Subject: Director General's Environmental Assessment Requirements for MP 08_0113 Proposed Housing for Seniors or People with a Disability, 216-222 Main Road and 21 Rowland Terrace, Toukley.

Following a review of the Preliminary Assessment and accompanying architectural plans, prepared by Ancher, Mortlock & Woolley, dated 19 November 2008, the Department reiterates its continued and ongoing concern with the excessive height, bulk and scale of the development.

Attachment 1 Director-General's Environmental Assessment Requirements

ELEVATION FROM LAKE

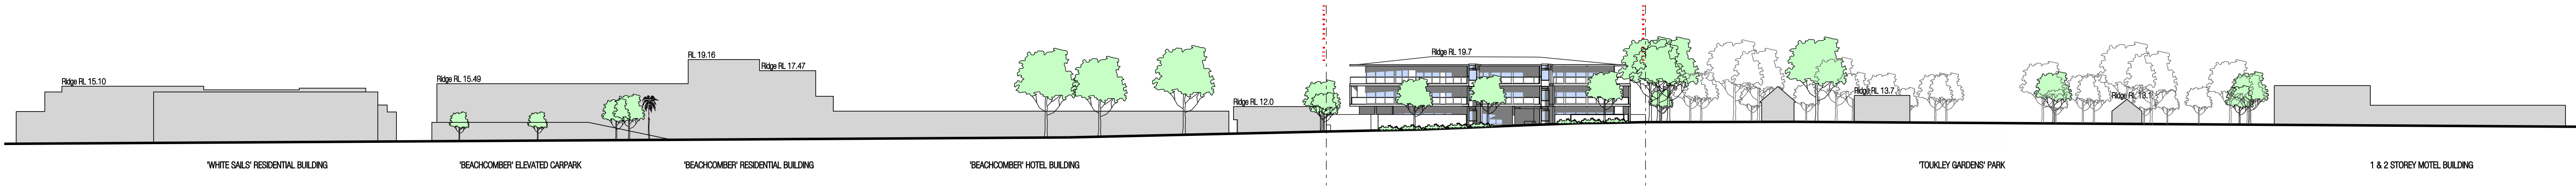
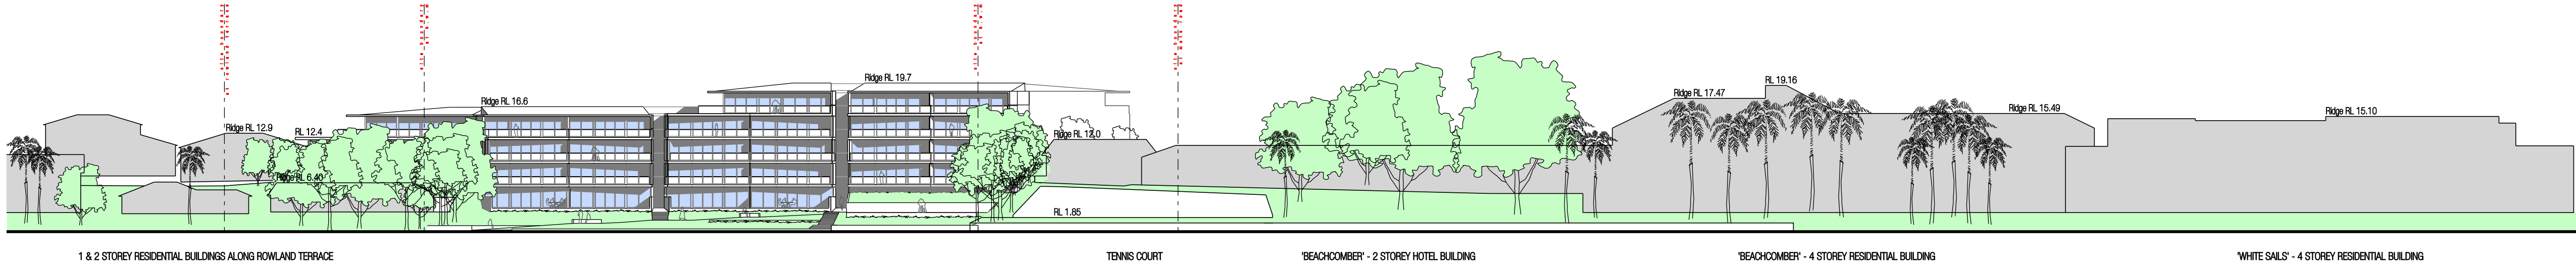
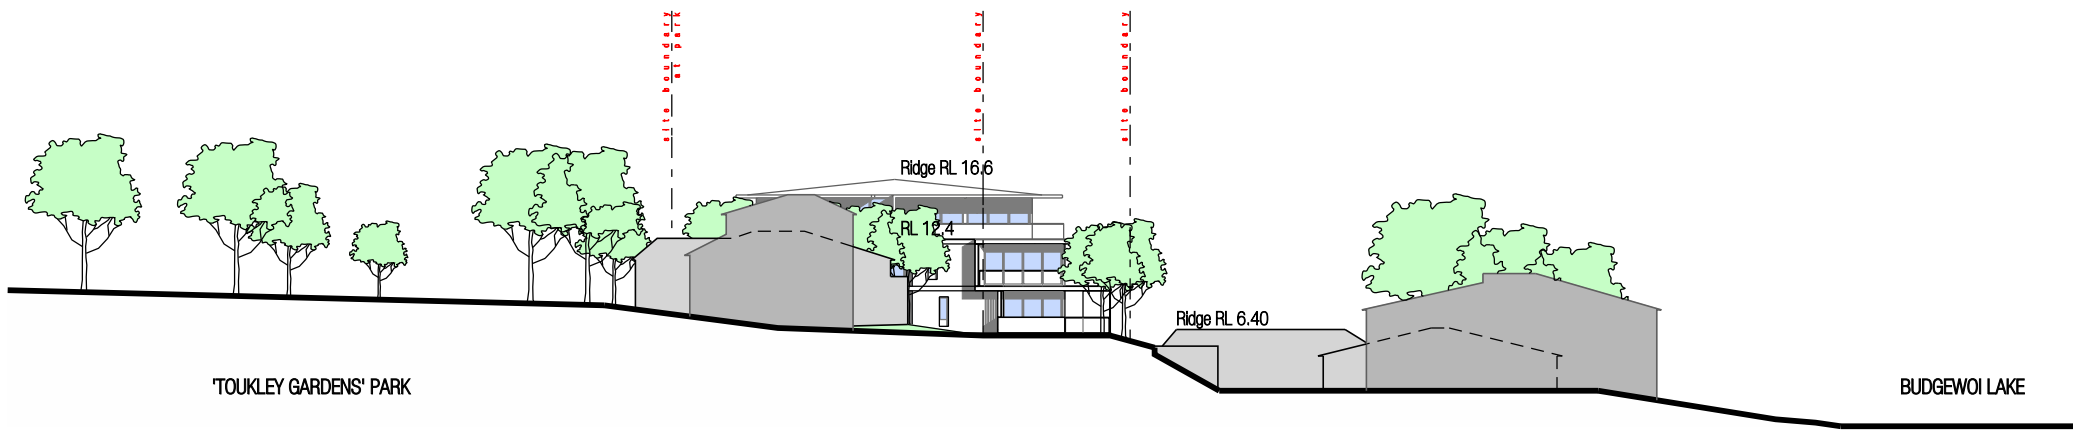
You are strongly encouraged to reconsider your proposal in light of these concerns and provide a proposal that is a maximum of 4 residential storeys to the foreshore and 3 residential storeys to the Main Road grading to a low scale 2 residential storeys at Rowland Terrace.

Furthermore, the separation between buildings should be increased to avoid the continuous wall effect when viewed from the water.
